Application for approval of details reserved by condition.
Town and Country Planning Act 1990
Planning (Listed Buildings and Conservation Areas) Act 1990

Outline application with some matters reserved for the erection of 90 No. dwellings with associated access & open space. This is a Departure from the Development Plan.

Planning condition 14 of case ref: P/58/15/OUT pertains to works required to be undertaken to Summer Lane and Pagham Lane under s278 of the Highways Act prior to first occupation of the development.

PROJECT SUMMER LANE, PAGHAM				CLIENT HANBURY PROPERTIES LTD	
DRAWING TITLE SECTION 278 HIGHWAY WORKS				vectos. 4th Floor Oxford Place, 61 Oxford Street, Manchester, M1 6EQ	
DRAWN AM	CHECKED PW	DATE 16.02.2021	SCALE AT A1 1:200	DRAWING NUMBER VD16396-ID-SK-0005	REVISION A

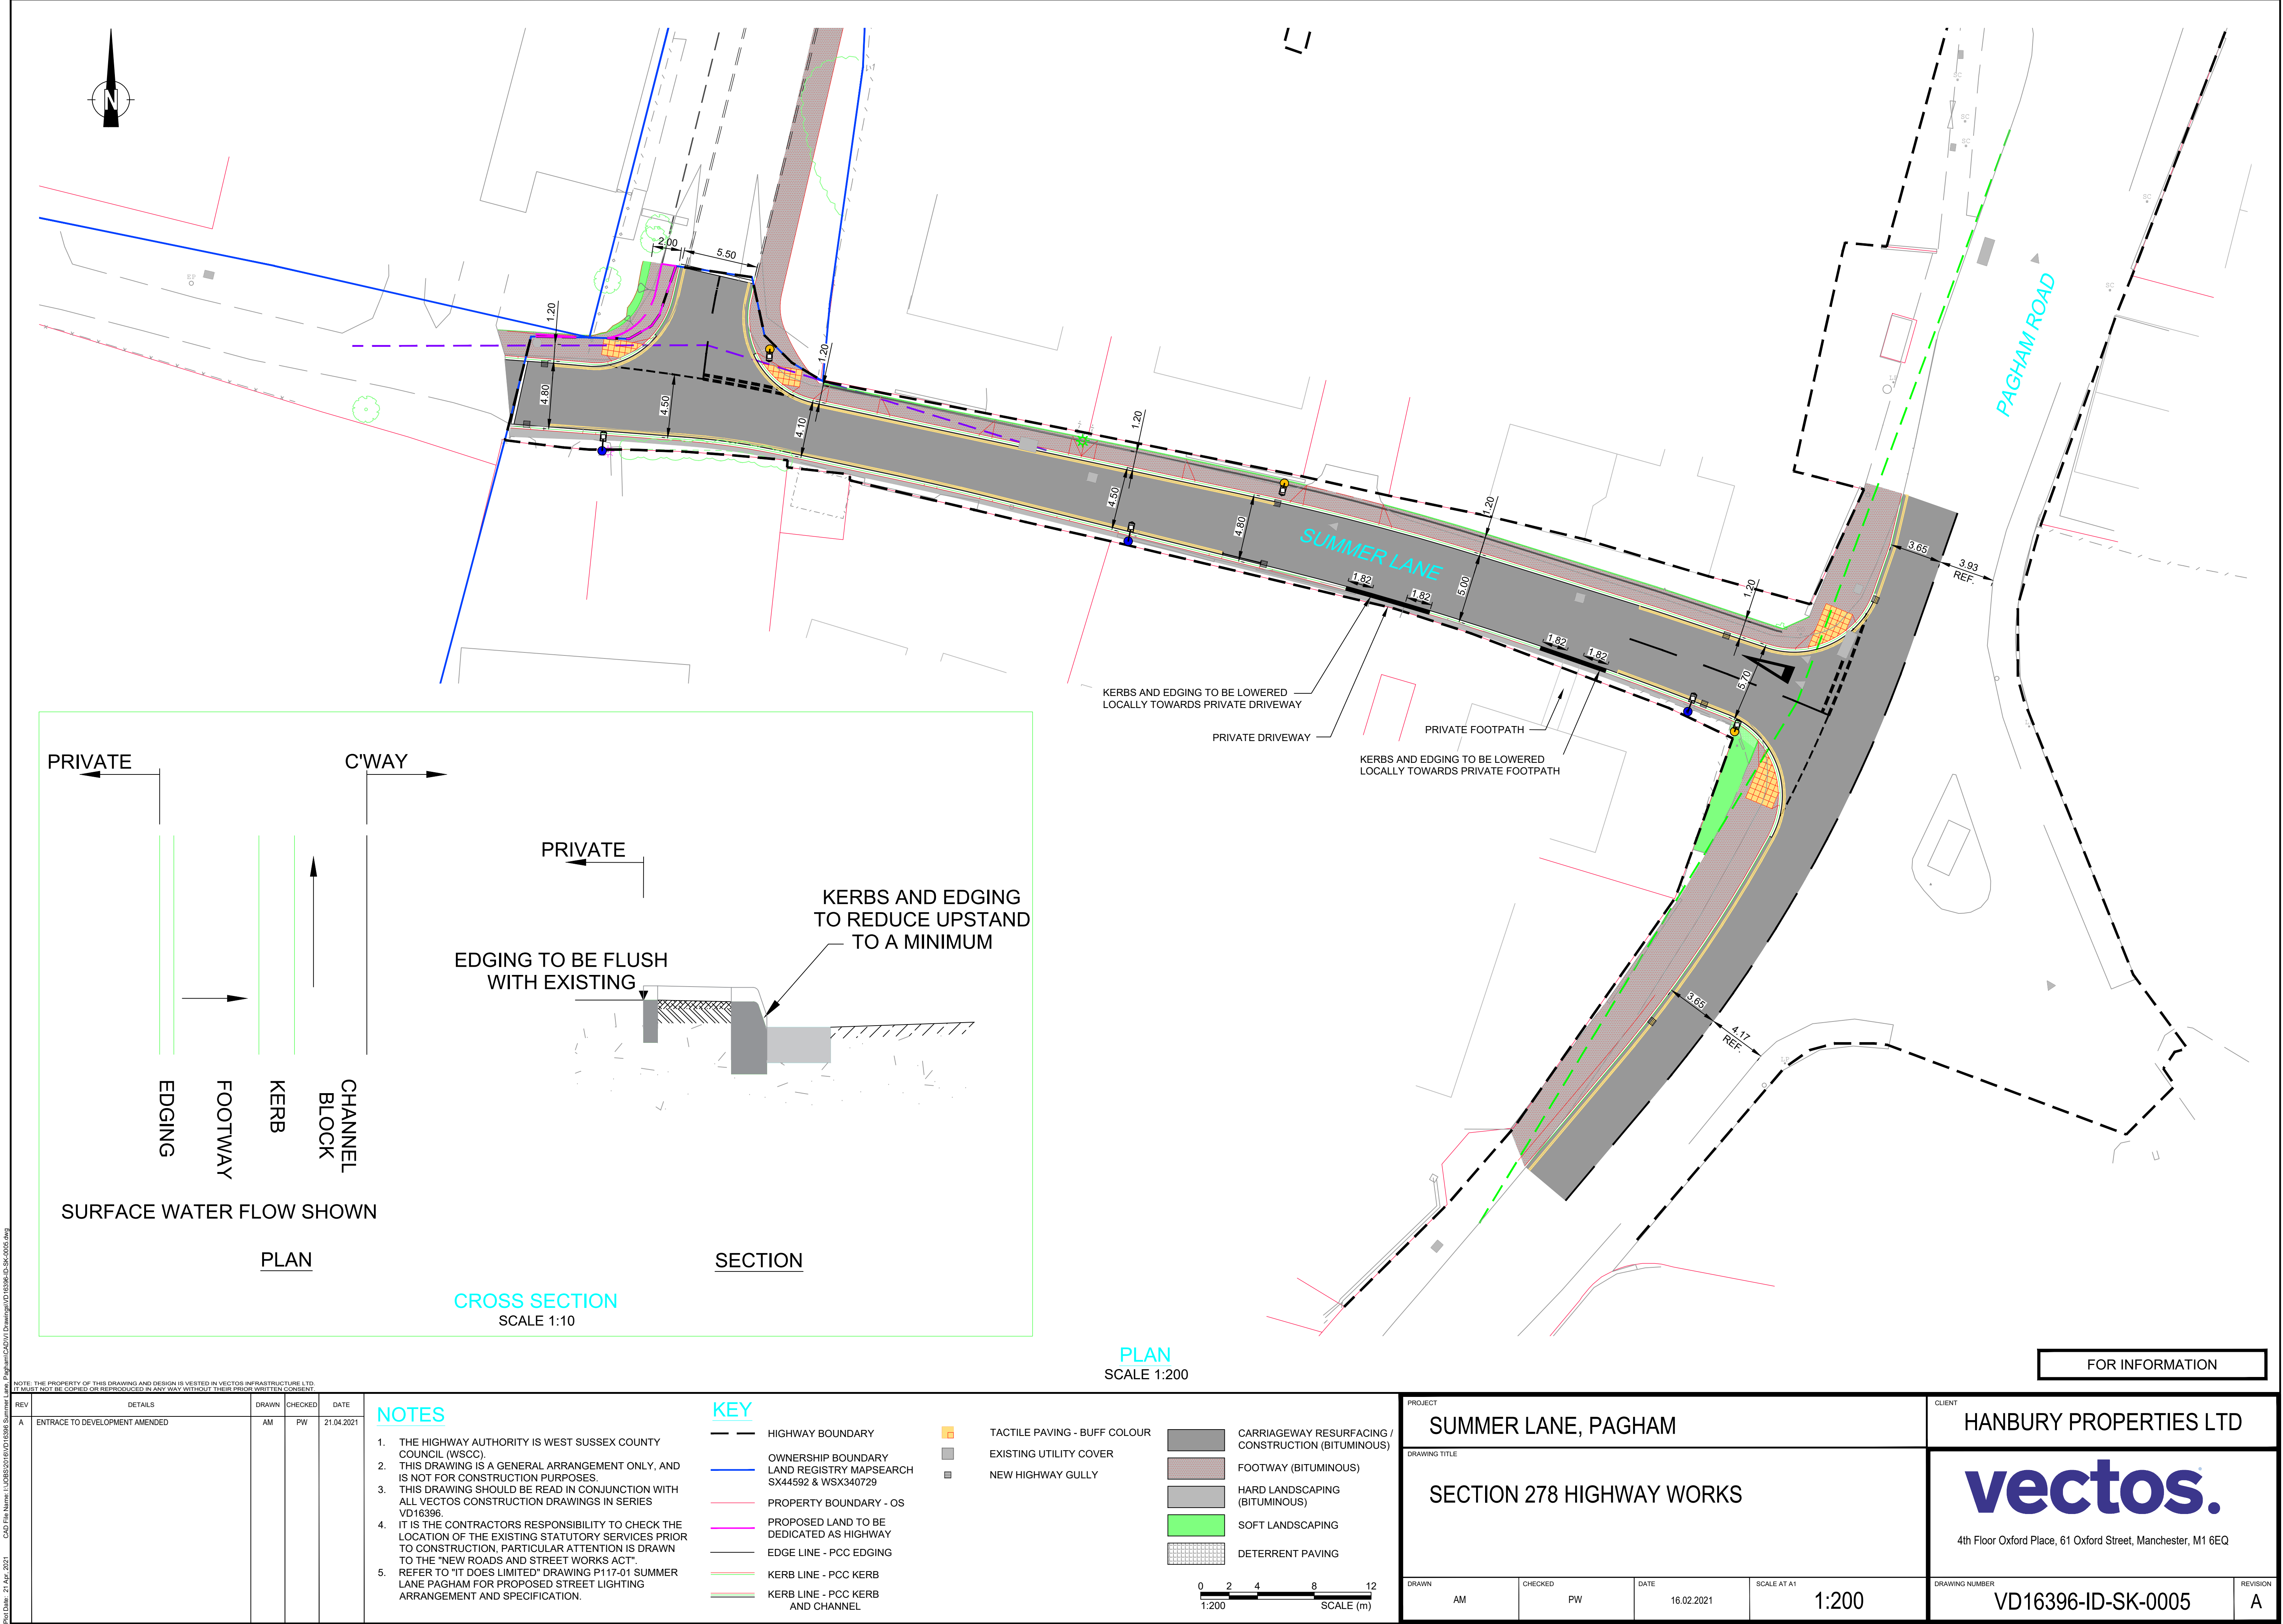
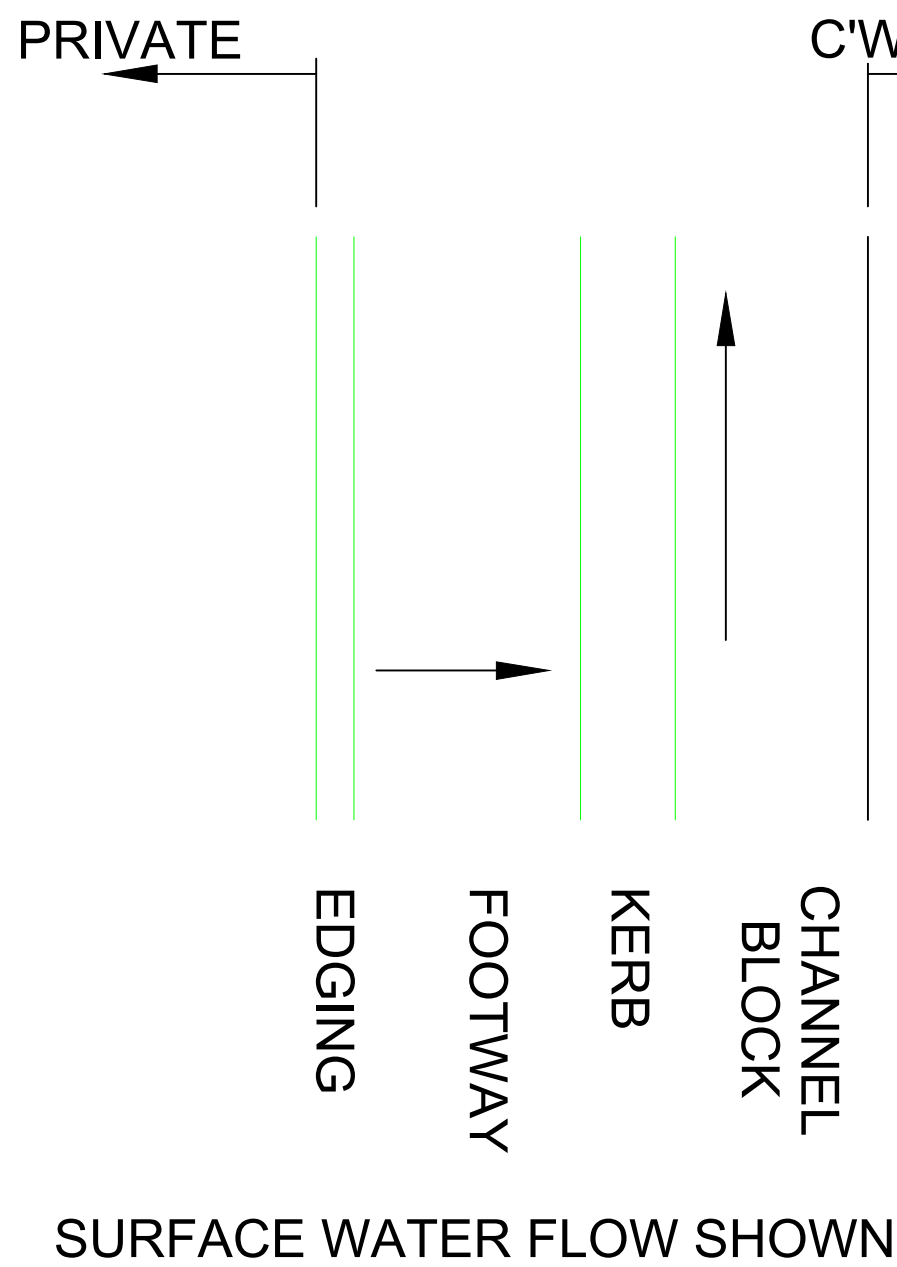
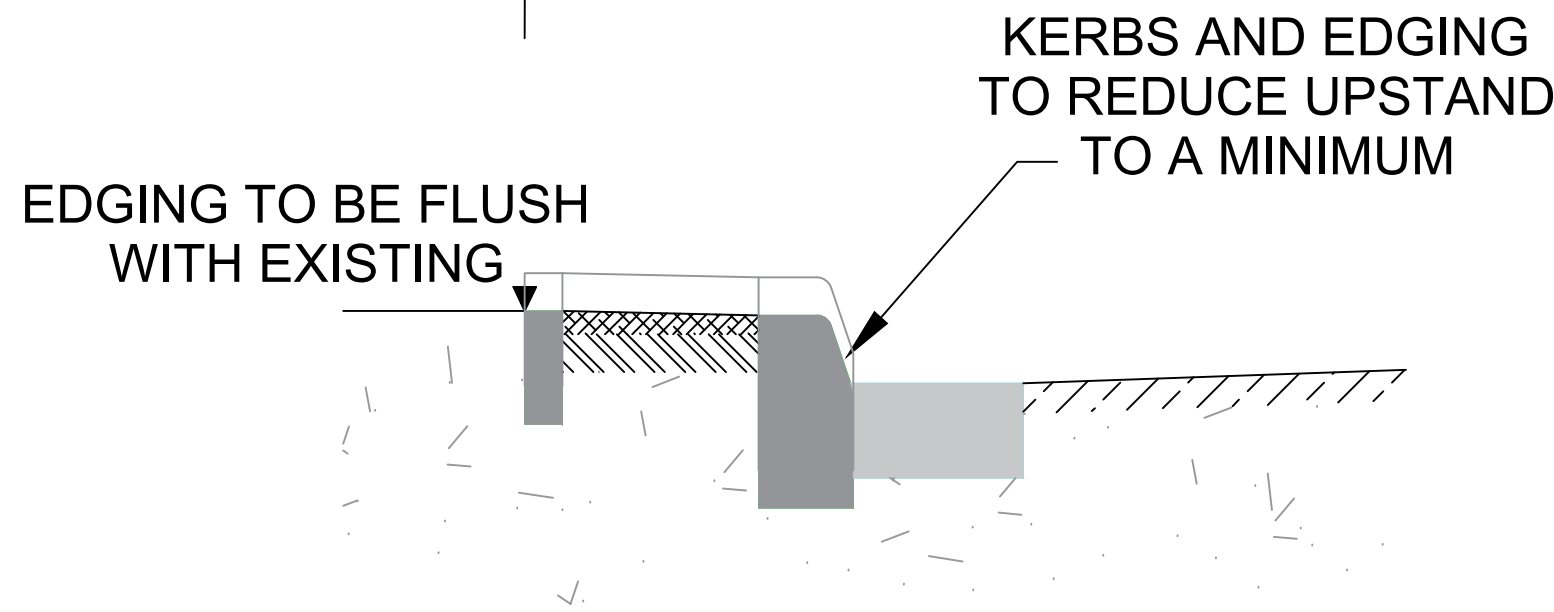
Following on from site discussions, and the submission of drawing no. VD16396-ID-SK-0005, the Highway Authority has agreed to revised details for the proposed s278 works which will reduce the width of some sections of the footpath from 1500mm to 1200mm. This minor proposed change is considered
